Statement of Response to the Notice of Pre-Application Consultation Opinion

Strategic Housing Development -Knocknacarra District Centre, Gort na Bró, Rahoon, Galway

Document Title: Statement of Response

Document File Name: **SOR F - 180531 - 2019.11.08**

Drawing file: Traffic and Roads / HT 0102 - General Arrangement.pdf

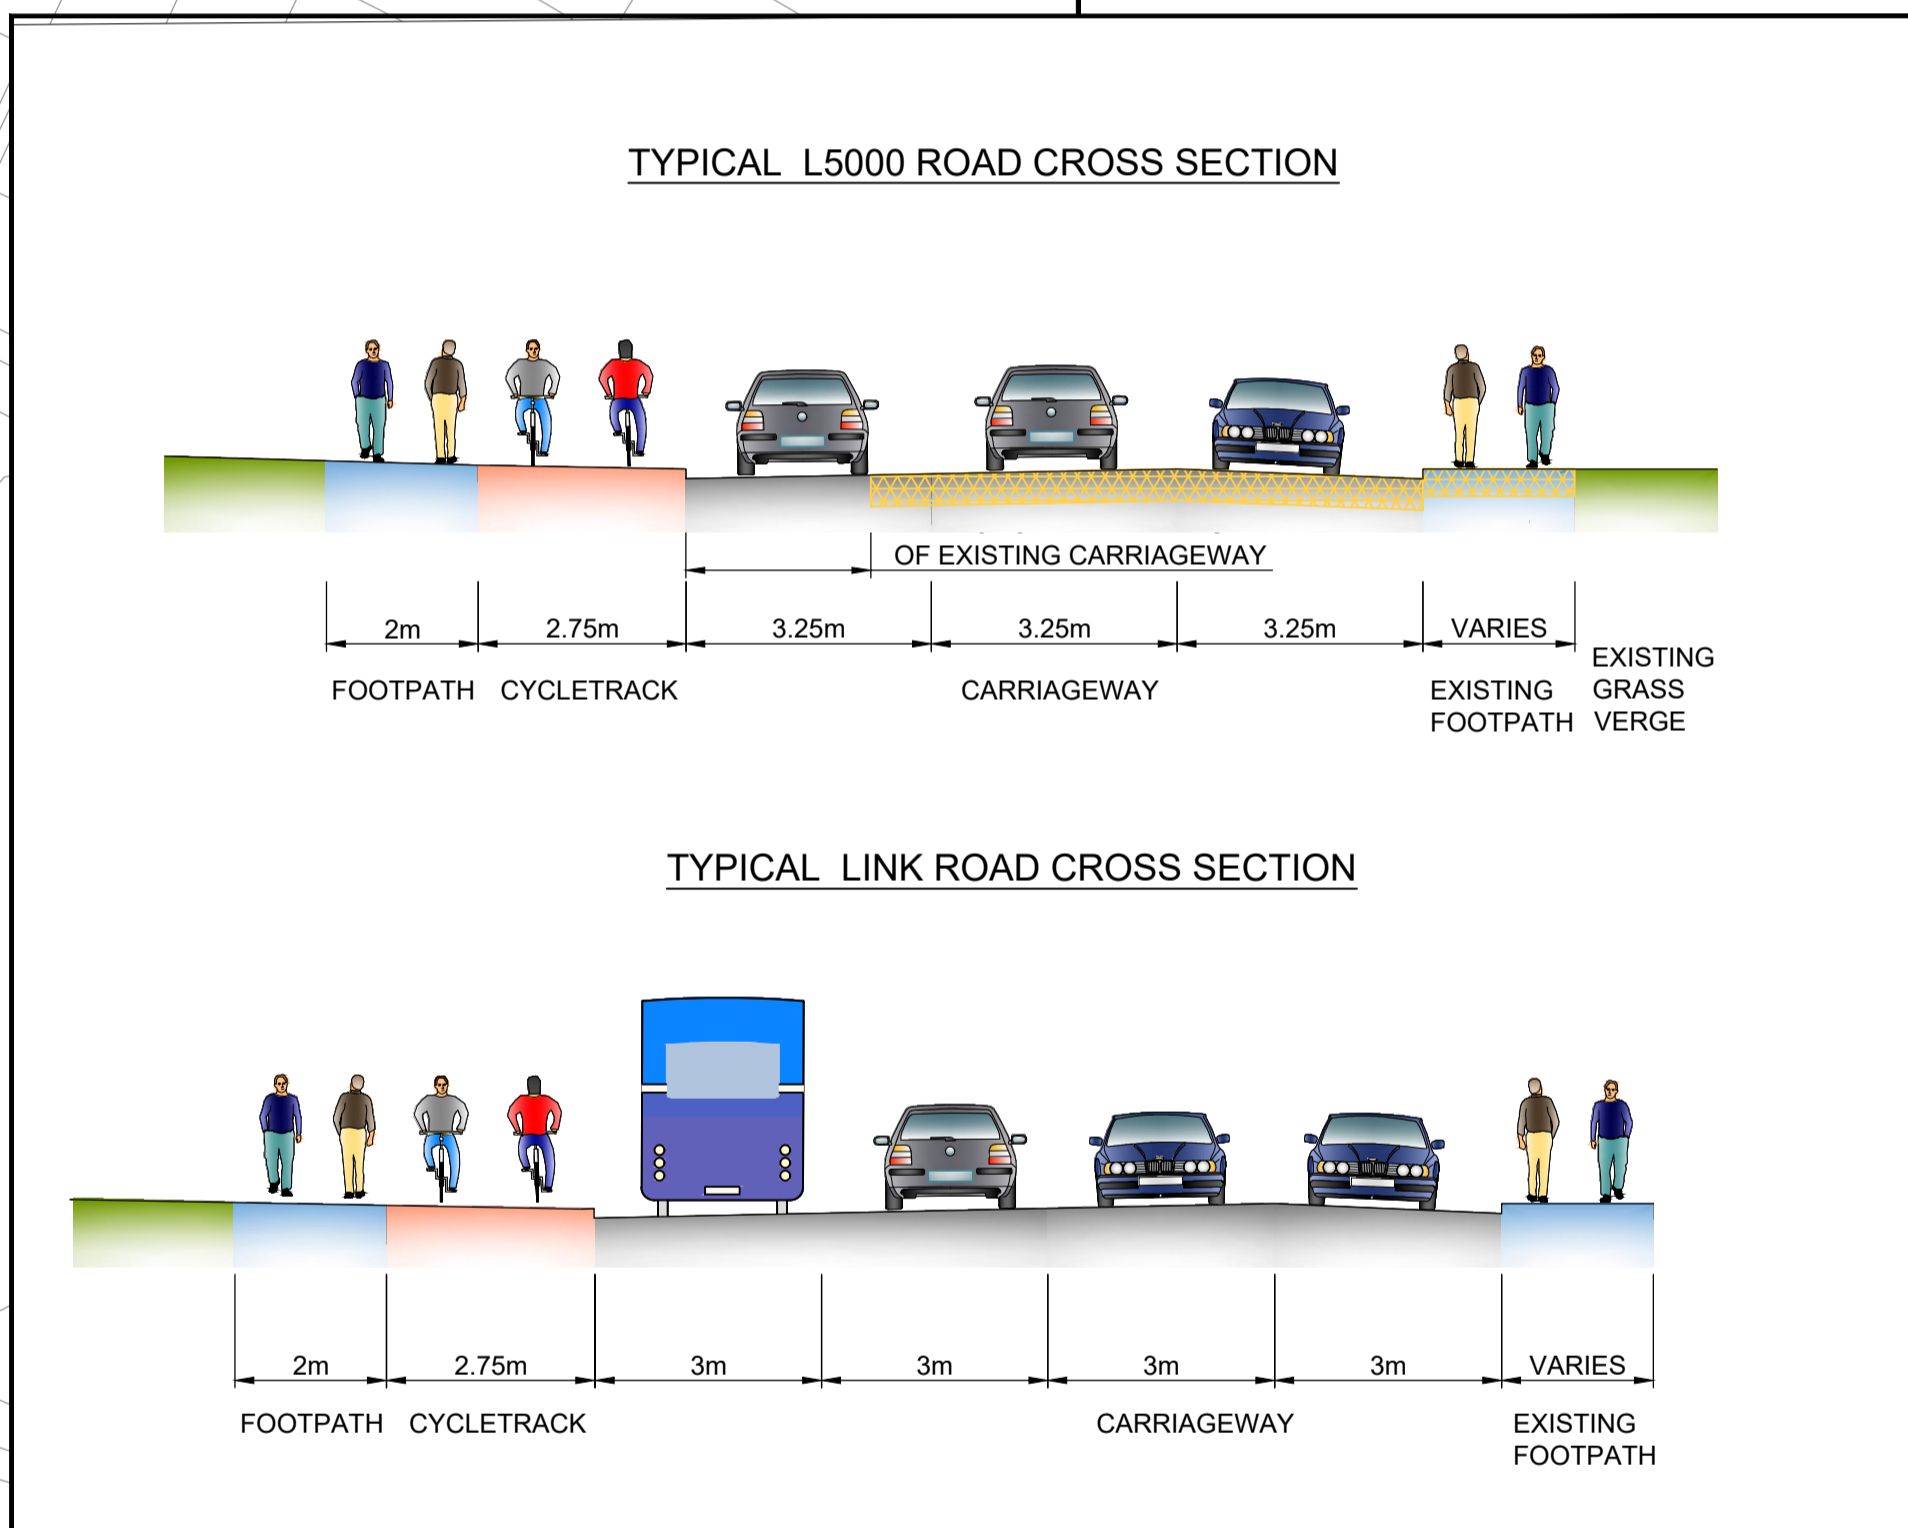
'A detailed map illustrating the proposed integration with necessary requirements for the road network, including the N6 Galway Bypass.'

Drawing No: 5168265/ATK/HT/0102 – General Arrangement prepared by Atkins

The drawing referred to above illustrates the interaction of the proposed development and the surrounding network and the proposed N6 scheme. Drawings and Reports prepared by Atkins sets out additional details in relation to the interaction of the proposed development and the existing road network. It is considered that the information set out above addresses the requirements of ABP in respect of this matter.

Design Development from Stage 2 Application

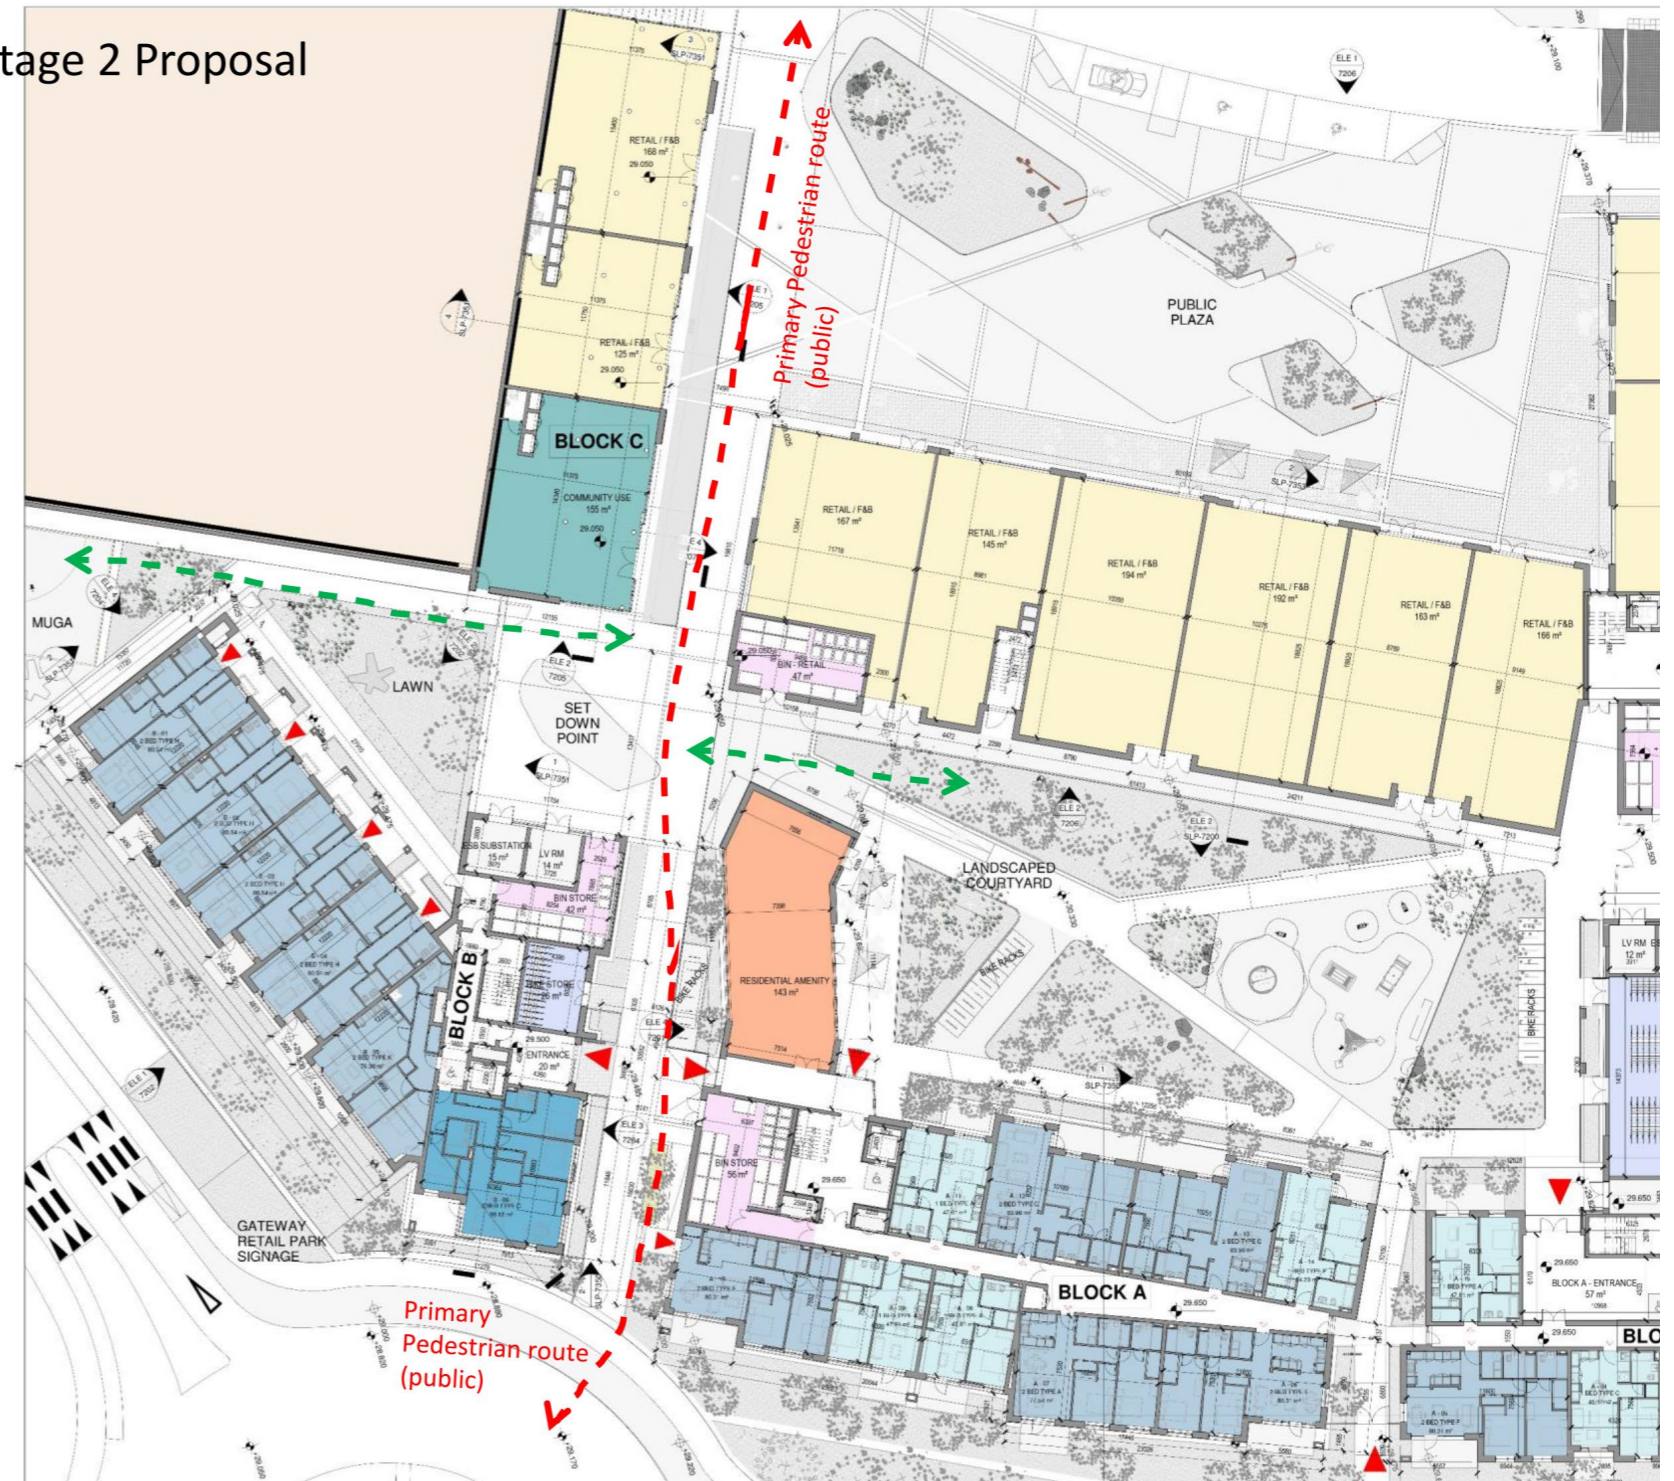
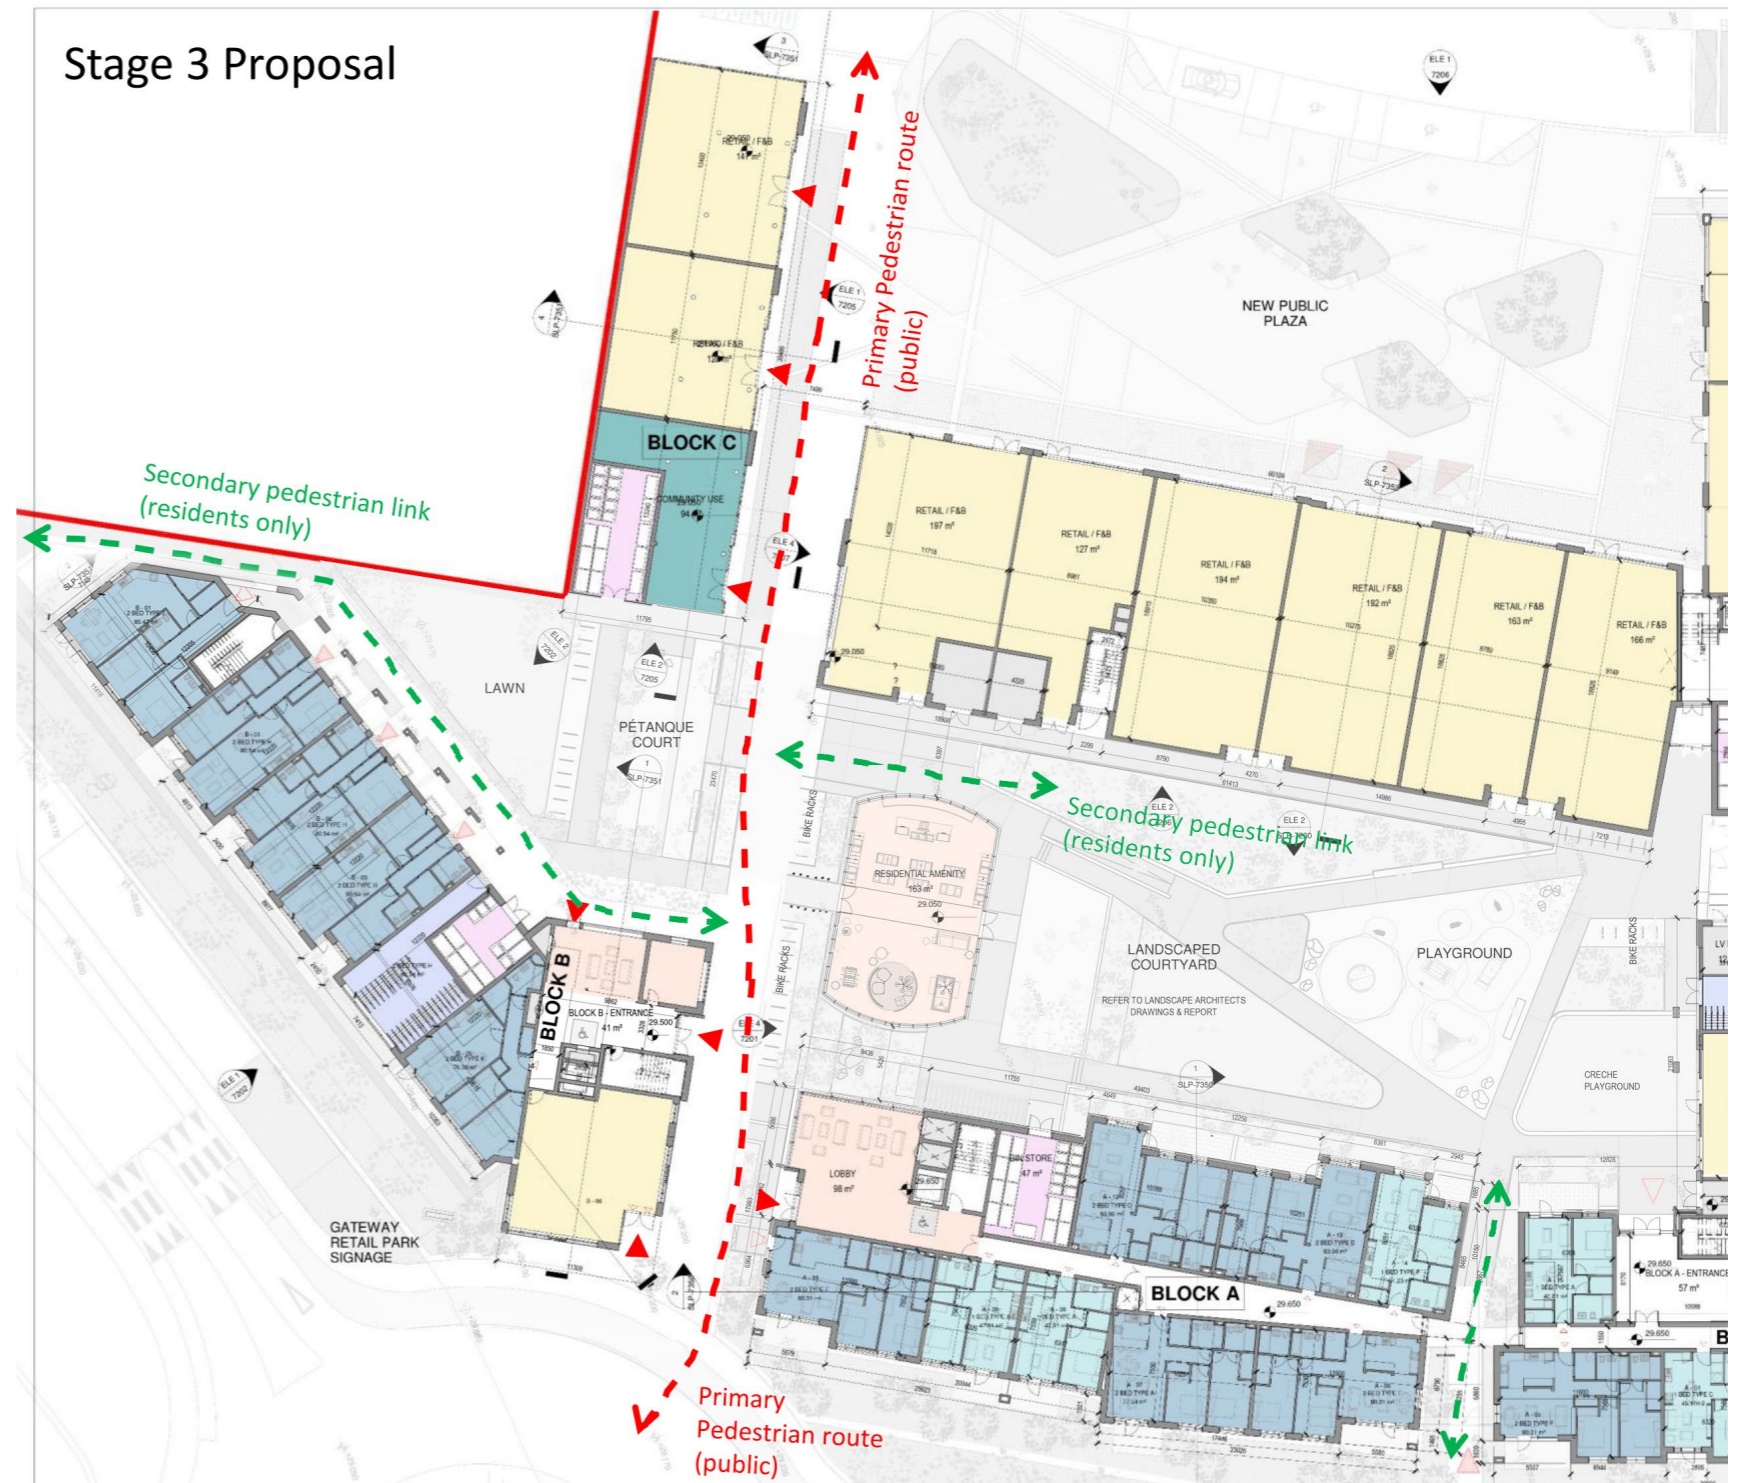
Further consideration and/or justification of documents as they relate to the proposed development strategy for the site in particular the design and relationship between Block B and the Western Distributor Road, the public pedestrian pathway between Block B and Block A and the two communal open space areas to the side and rear of Block B including the courtyard and the MUGA. Particular regard should be has to the 12 criteria set out in the Urban Design Manual which accompanies the 'Guidelines for Planning Authorities on Sustainable Development in Urban Areas (May 2009) and the 'Urban Development and Building Heights Guidelines' Further consideration of these issues may require an amendment to the documents and/or design proposals submitted.'

The Design Team has given careful consideration to the matters raised by the Board, both at the meeting on 18th July 2019, and in the Notice of Pre-Application Consultation Opinion. In this regard, Block B has been redesigned to address the Western Distributor Road by elongating the building façade along the street to create a more unified street frontage.

This building now addresses the street in a more suitable manner, creates an urban edge and distinguishes between the development to the adjoining site reserved for a District Centre Use. The design of Block B has been amended to be a more linear block along the Western Distributor Road so that the space to the rear is enlarged to provide a more meaningful open space and also to allow sunlight to penetrate the public realm. This will ensure a clear definition between public, semi private, and private space. The open space will be overlooked, and this amenity is considered as a usable integrated element in the design of the development which will benefit the residents. The boundary treatments will be important at this location and provide defensible space.
